From: Simon Davis <Simon.Davis@arun.gov.uk>
Sent: 01 December 2020 14:54
To: Planning.Responses <Planning.Responses@arun.gov.uk>
Subject: FW: P/97/20/PL - Summer Lane, Pagham

Further Ecology Consultation Advice

From: Liz Annalls [REDACTED]
Sent: 01 December 2020 13:33
To: Simon Davis <Simon.Davis@arun.gov.uk>
Subject: RE: P/97/20/PL - Summer Lane, Pagham

Drawing Title
Proposed Site Plan
105 Unit Scheme

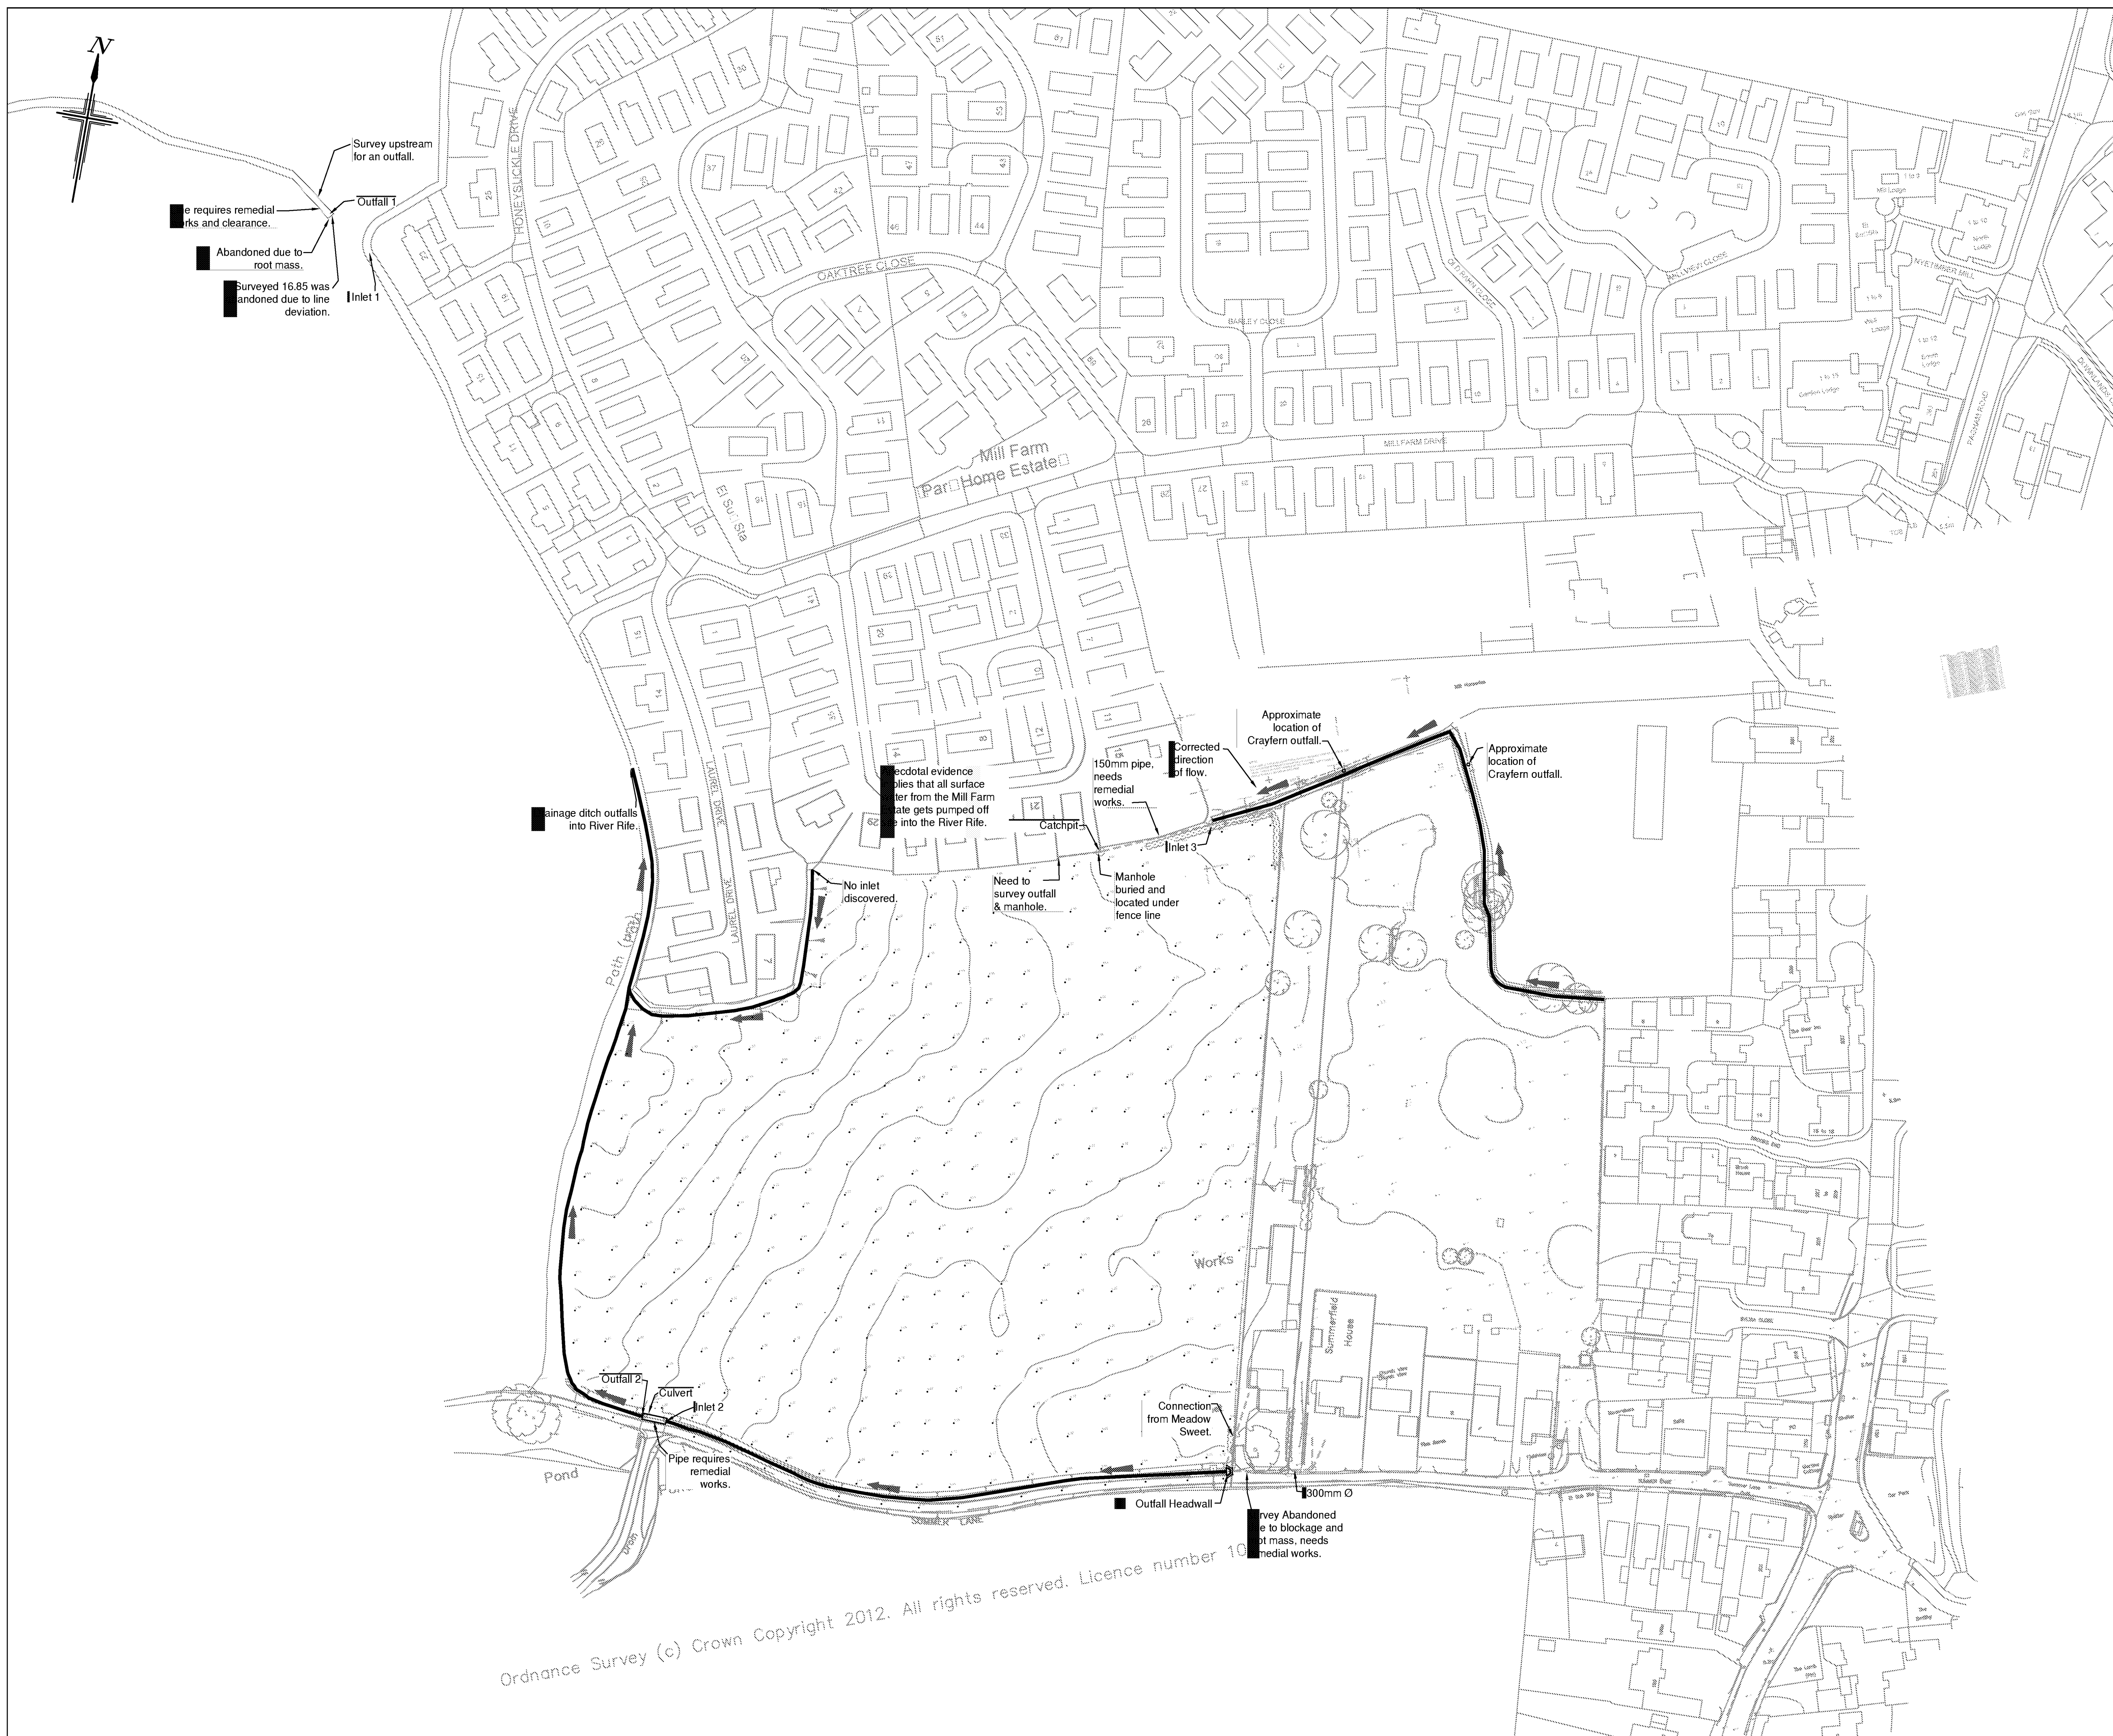
Our Engineer (Laura Gibbons) has concerns re biodiversity in respect of the proposed additional crossings over the ditch running along Summer Lane. She comments that:

The proposed revised plans will result in an increase in ditch crossing points. A matter that we raised on the original proposals. We believe that the increased crossings will lead to a deterioration in the condition of the watercourse. Loss of daylight, loss of habitat and significant restrictions upon access for maintenance will likely result in ecological detriment and an increase in flood risk. We therefore do not support this proposed change in plan and would request that the number of ditch crossings is reduced.

This application does increase the number of culverted crossings by 4 to 9 (there were 5 on the consented scheme).

Do you have any concerns due to this increase in culverts?

This was considered within the updated Ecological Mitigation Strategy (Oct 2020) where they state that

The additional loss of retained/created ditch habitat along the northern edge of Summer Lane from a re-plan where the drive access points are increased from five to nine is not considered significant as the mitigation strategy devised for the original scheme has provided greater than wet grassland creation in a SUDS strategy along the north western edge of the western parcel of the site (c2500m²). The creation of this new habitat is detailed in the ecological mitigation strategy and Landscape Plans for the scheme (IJLA, 2019, IJLA, 2020).

Due to this I am happy that this has been assessed.
